**APPLICATION BY NATIONAL GRID ELECTRICITY TRANSMISSION FOR AN
ORDER GRANTING DEVELOPMENT CONSENT FOR THE SEA LINK PROJECT**

APPLICATION REF: EN020026

**COMMENTS OF THE HISTORIC BUILDINGS AND MONUMENTS COMMISSION
FOR ENGLAND (HISTORIC ENGLAND) ON FURTHER INFORMATION/
SUBMISSIONS RECEIVED BY DEADLINE 1 AND DEADLINE 1A**

Comments on Outline Onshore Overarching Written Scheme of Investigation (OWSI) - Kent (Clean) – Applicants document reference: 7.5.4.2 (B); PINs Examination Reference: REP1-104

Document Ref: FIGURE 1	Scale: 1:15,000	Format: A3	Sheets: 1	Rev: 0
------------------------	-----------------	------------	-----------	--------

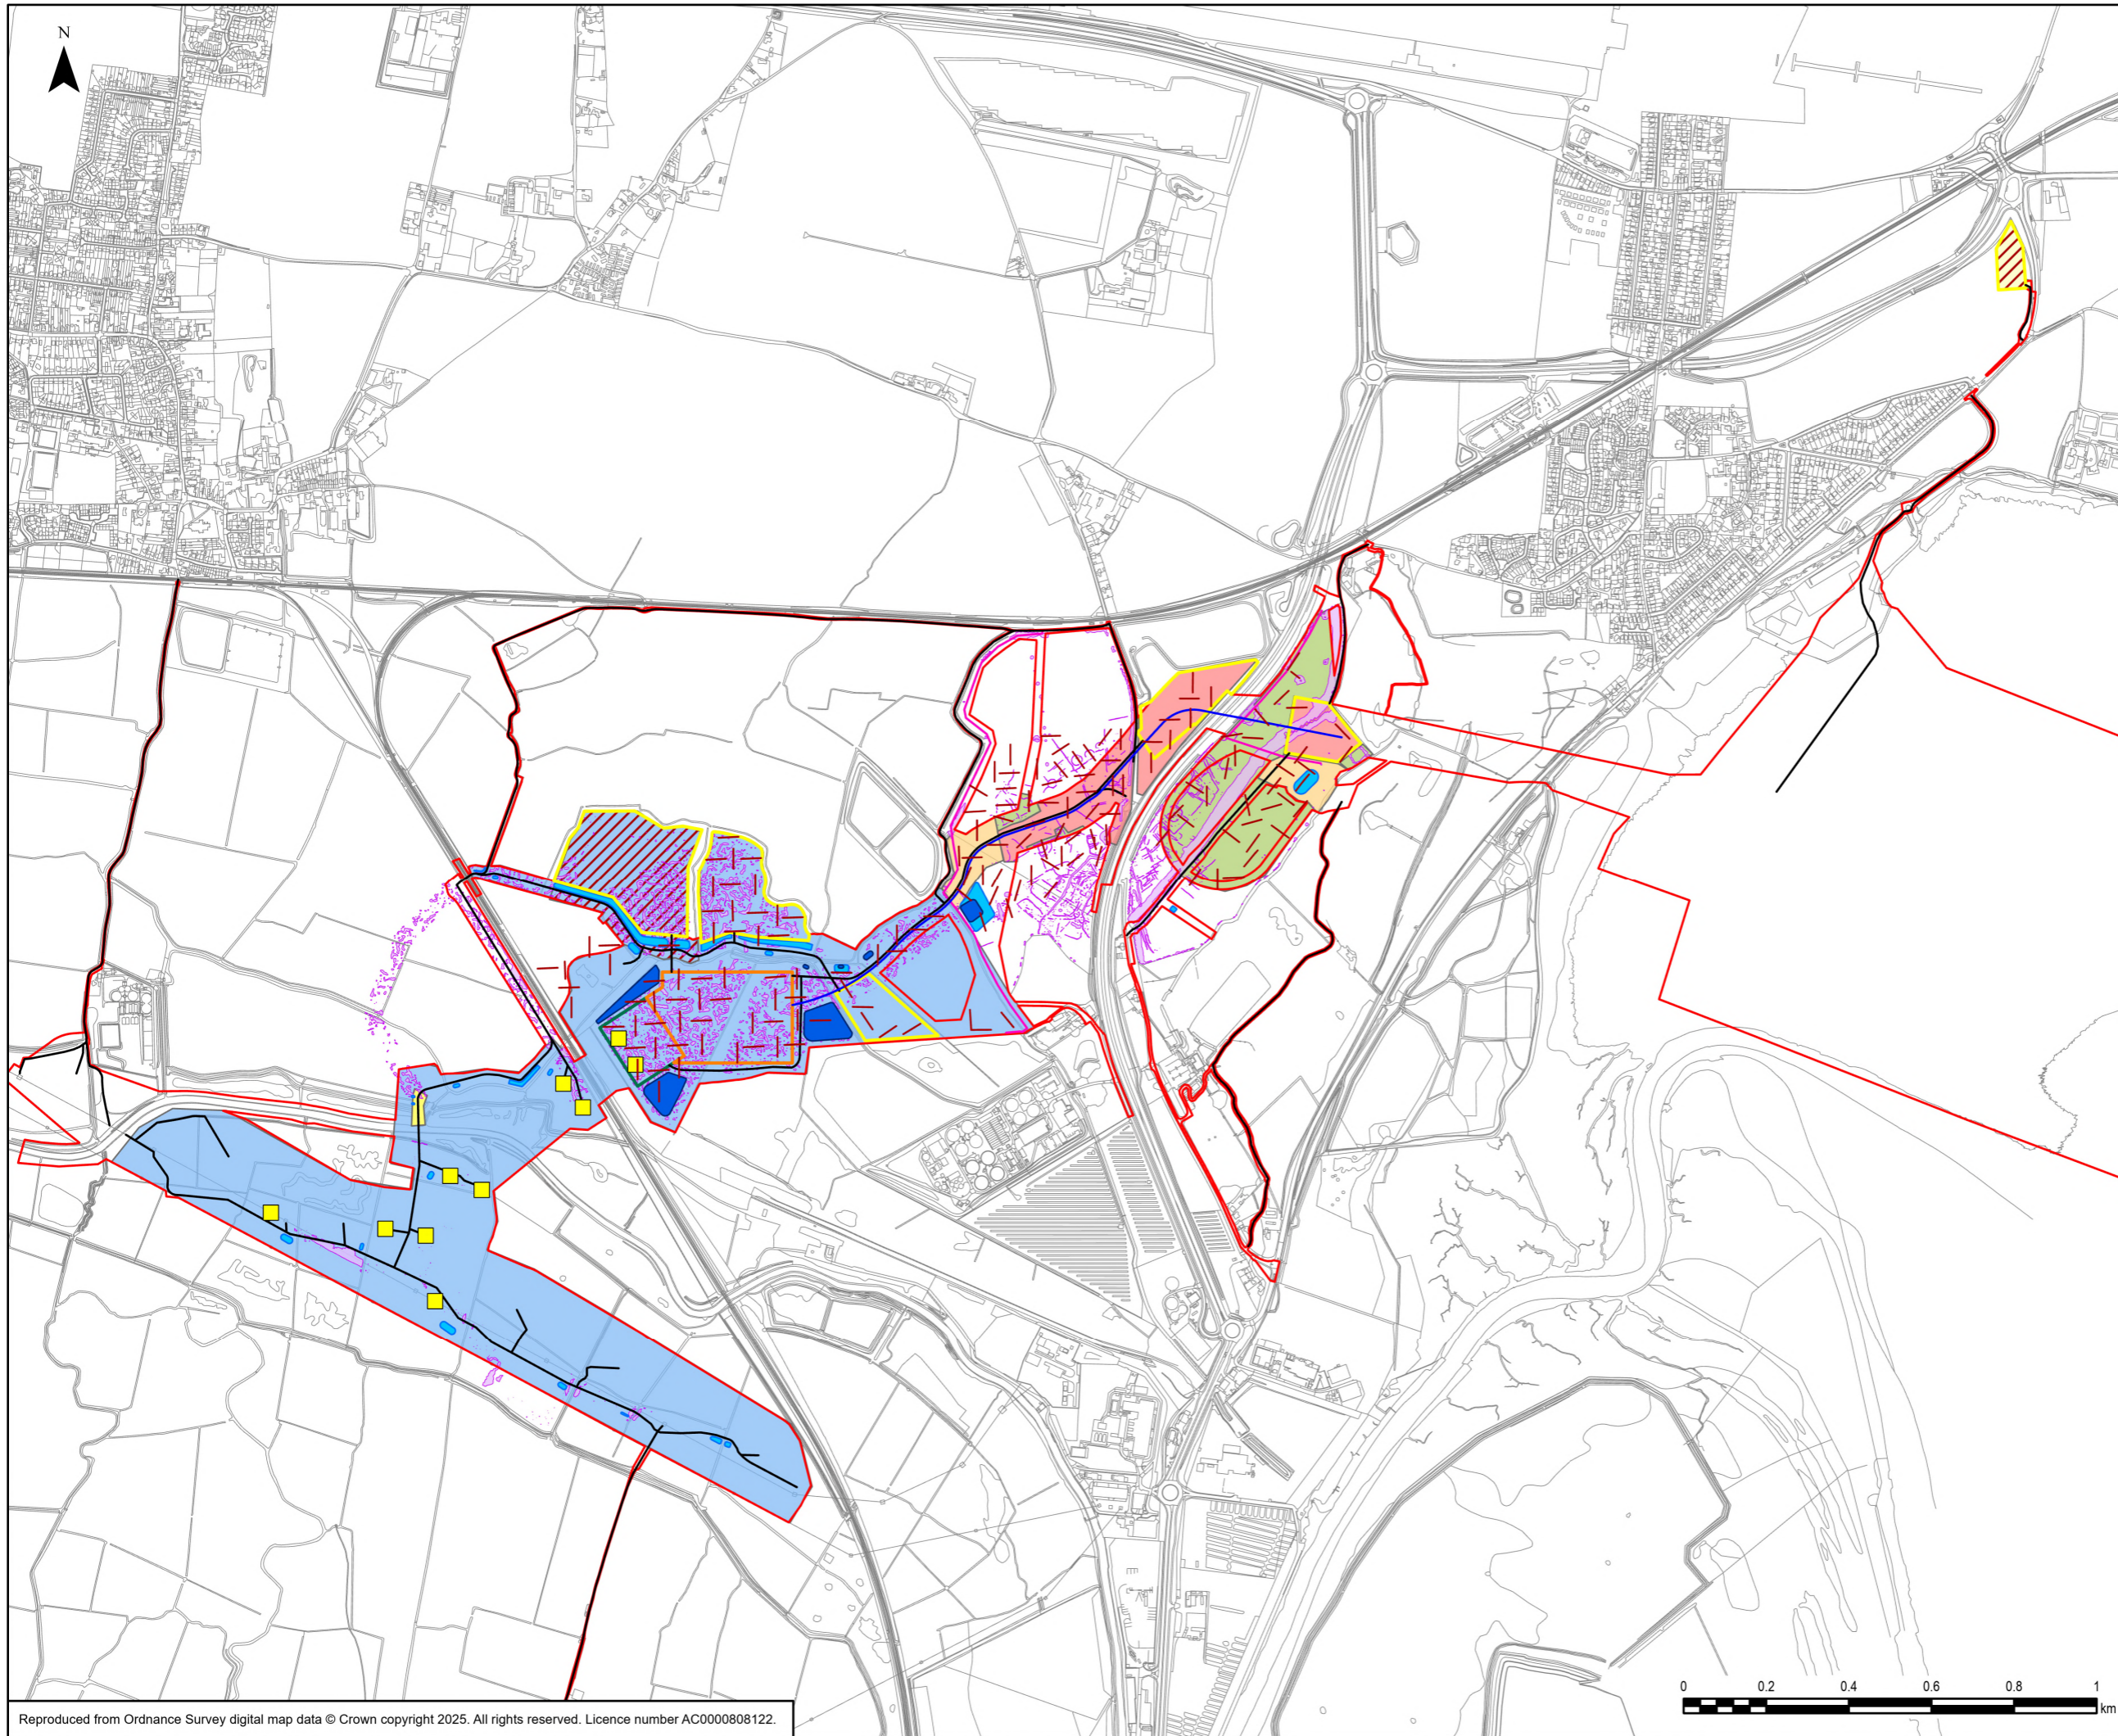
- Figure 1 - please include more detailed figures of zoned areas with geophysical survey results included.
